19 November 2021

REQUEST FOR ADVICE ON ENVIRONMENTAL IMPACT STATEMENT FOR UPPER SOUTH CREEK ADVANCED WATER RECYCLING CENTRE (AWRC) & BRINE PIPELINE (SSI-8609189)

Andrew Mooney
ACTING MANAGER, STRATEGIC LAND USE PLANNING

Figure 4-20 Pipeline construction corridor widths and layouts

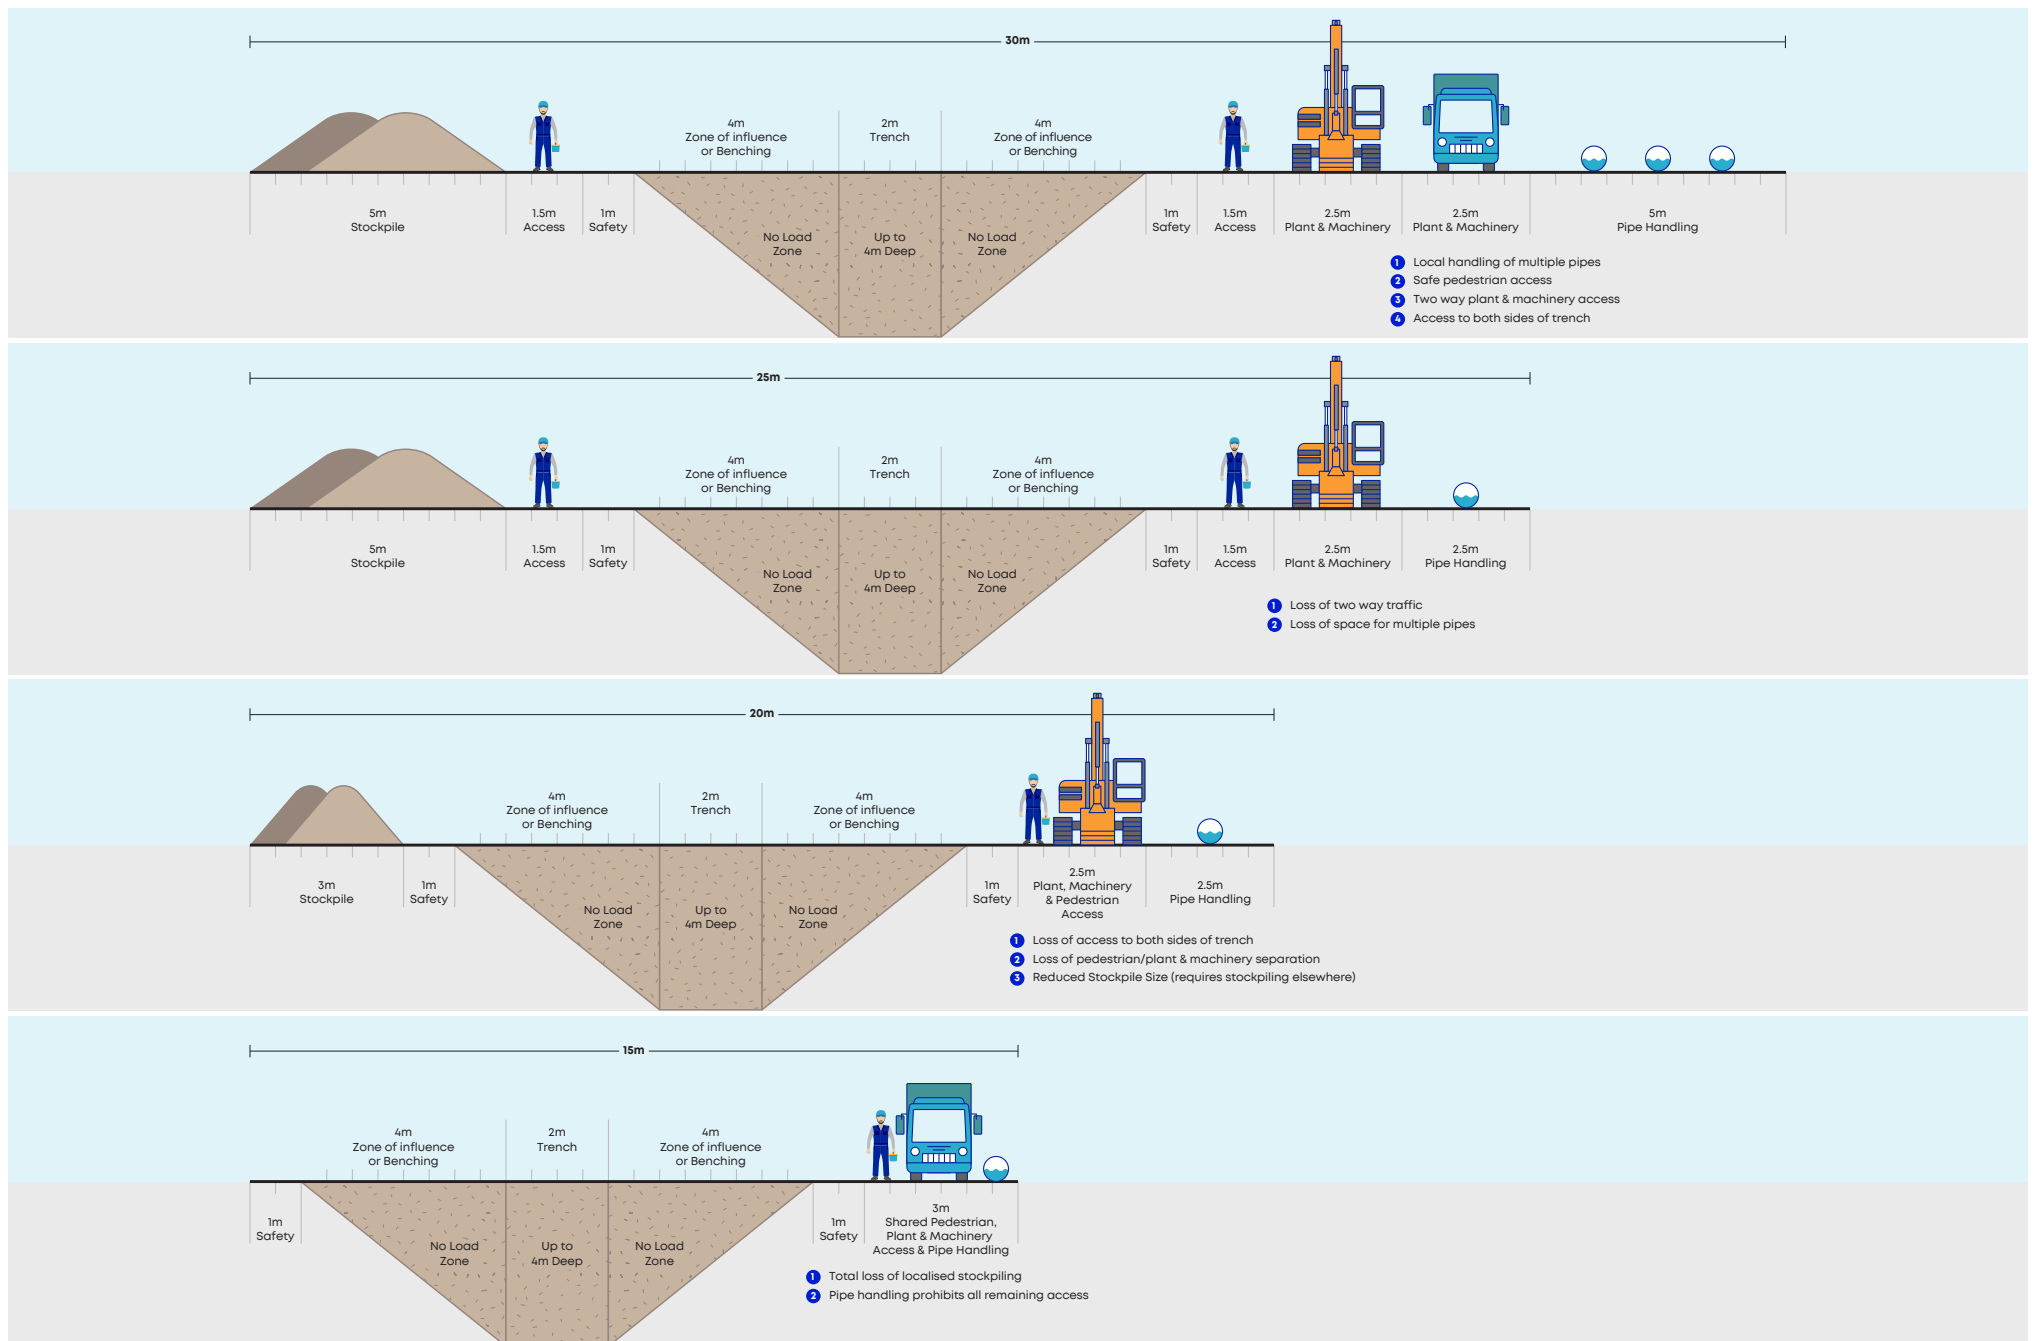
Council will require further clarification at detailed design stage to understand the construction methodology and construction corridor width of the brine pipeline alignment to determine the impact construction will have on the local road network, pedestrian areas and Council infrastructure.

To avoid impacts on the established urban areas and infrastructure the future design plans developed by Sydney Water should minimise the width of trenching through the urban areas of Fairfield City. Accordingly Sydney Water will need to liaise further with Council on this issue and measures (such as a construction management plan) will need to be investigated to minimise disruption for the community and interference for Council infrastructure projects, including any upgrade/maintenance works Council is planning to undertake.

Figure 4-24 Indicative locations of construction compounds

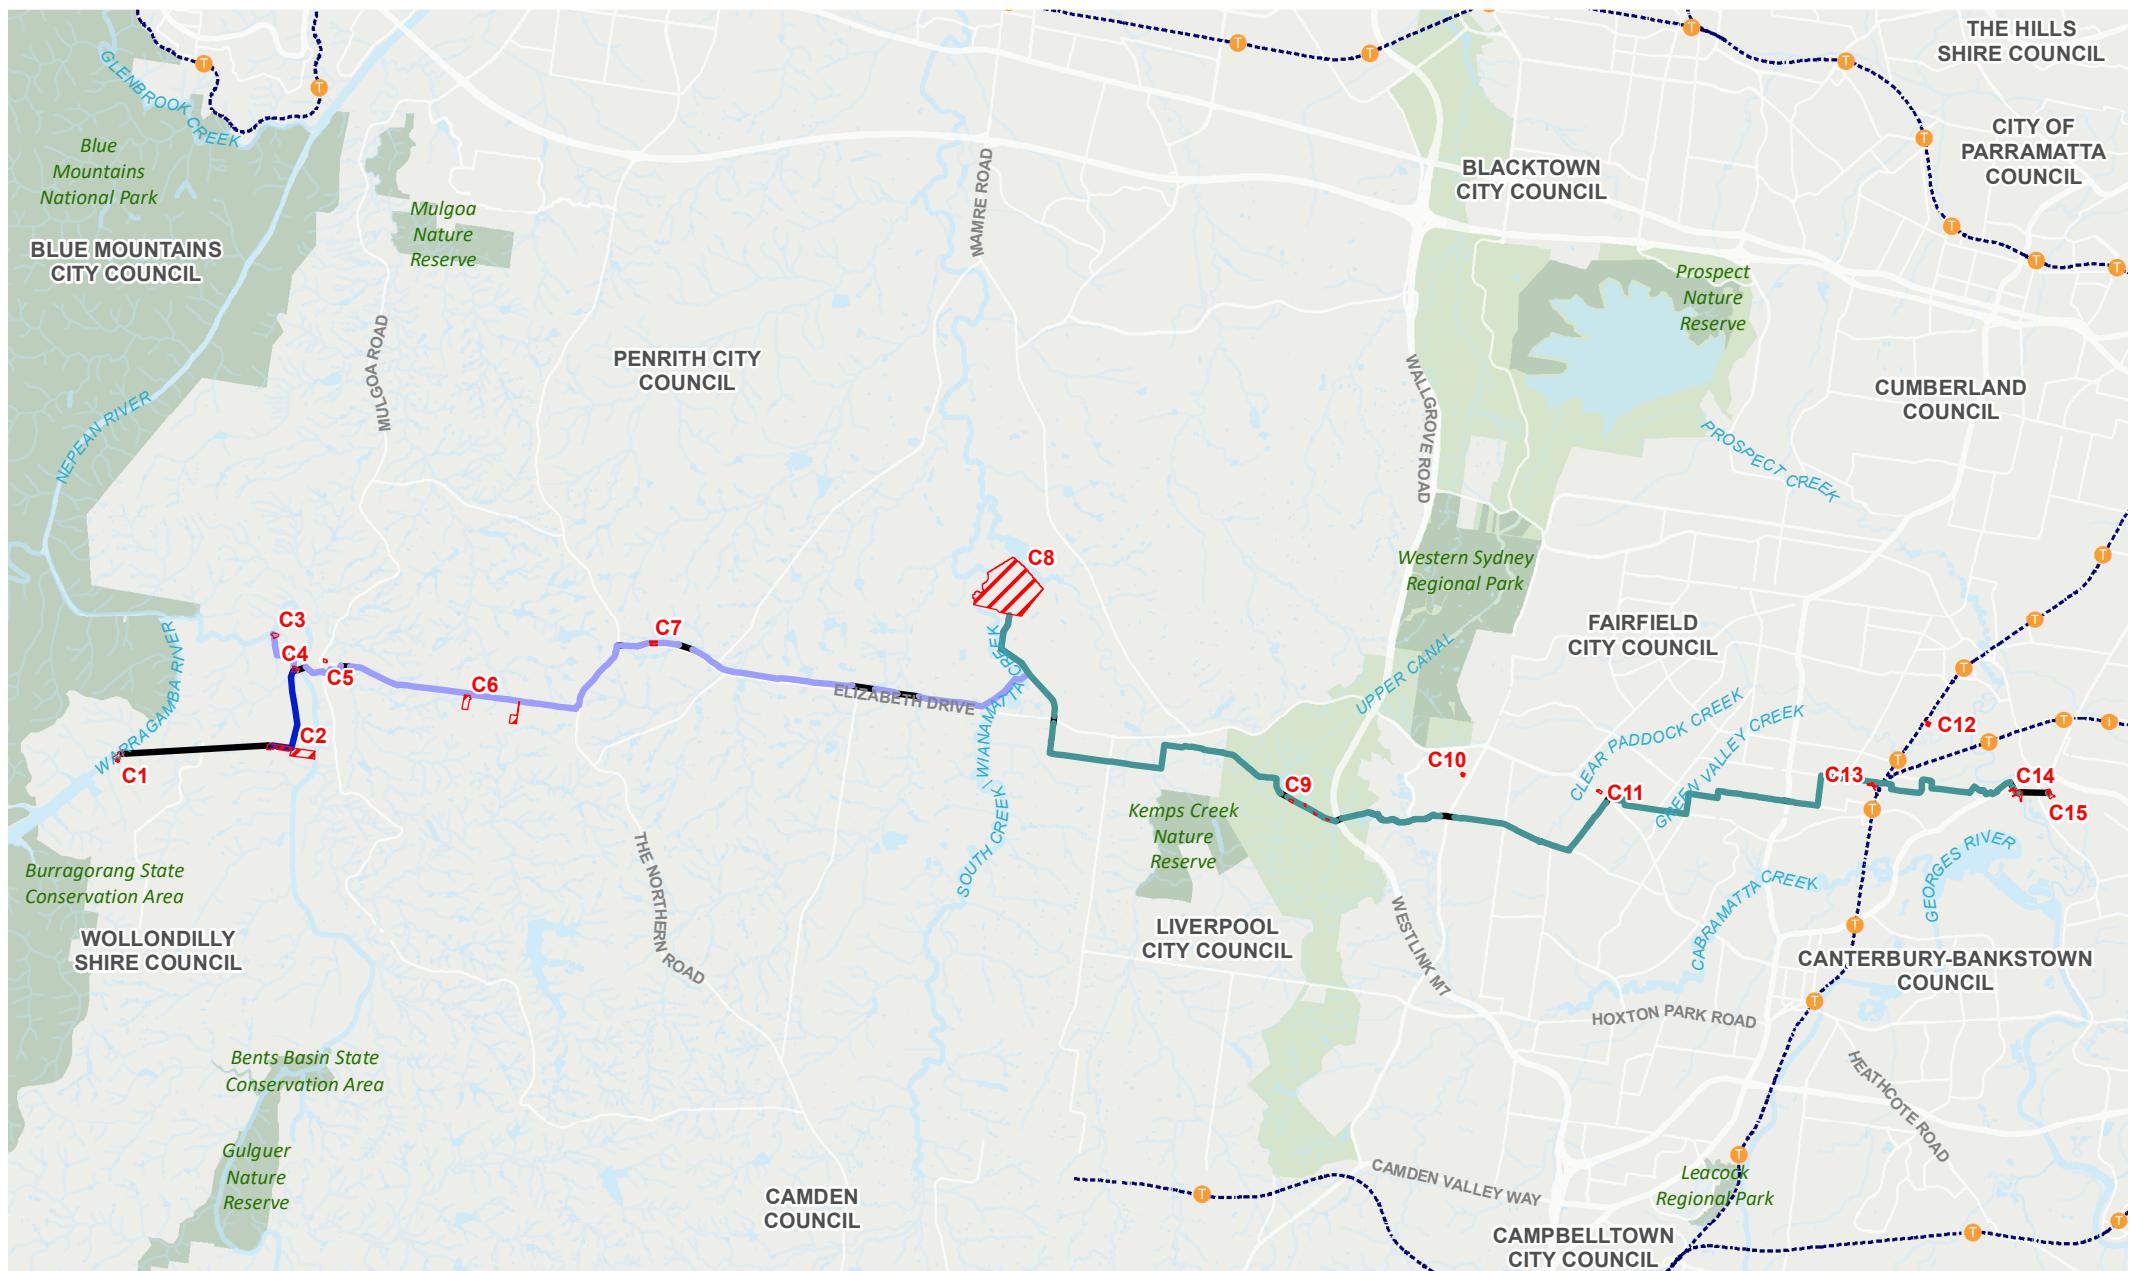
As previously advised to Sydney Water, Council does not support the provision of a work compound and alignment of the pipeline for Cabravale Park. Council also acknowledges that Sydney Water has been working with relevant rail authorities to secure an alternative alignment under the passenger and freight line corridors directly to the east that would avoid potential impacts on Cabravale Park.

Prior to any site compound establishment an Access over Community Land permit must be obtained (fees apply) with the lodgement of a Dilapidation Report relevant to the site.
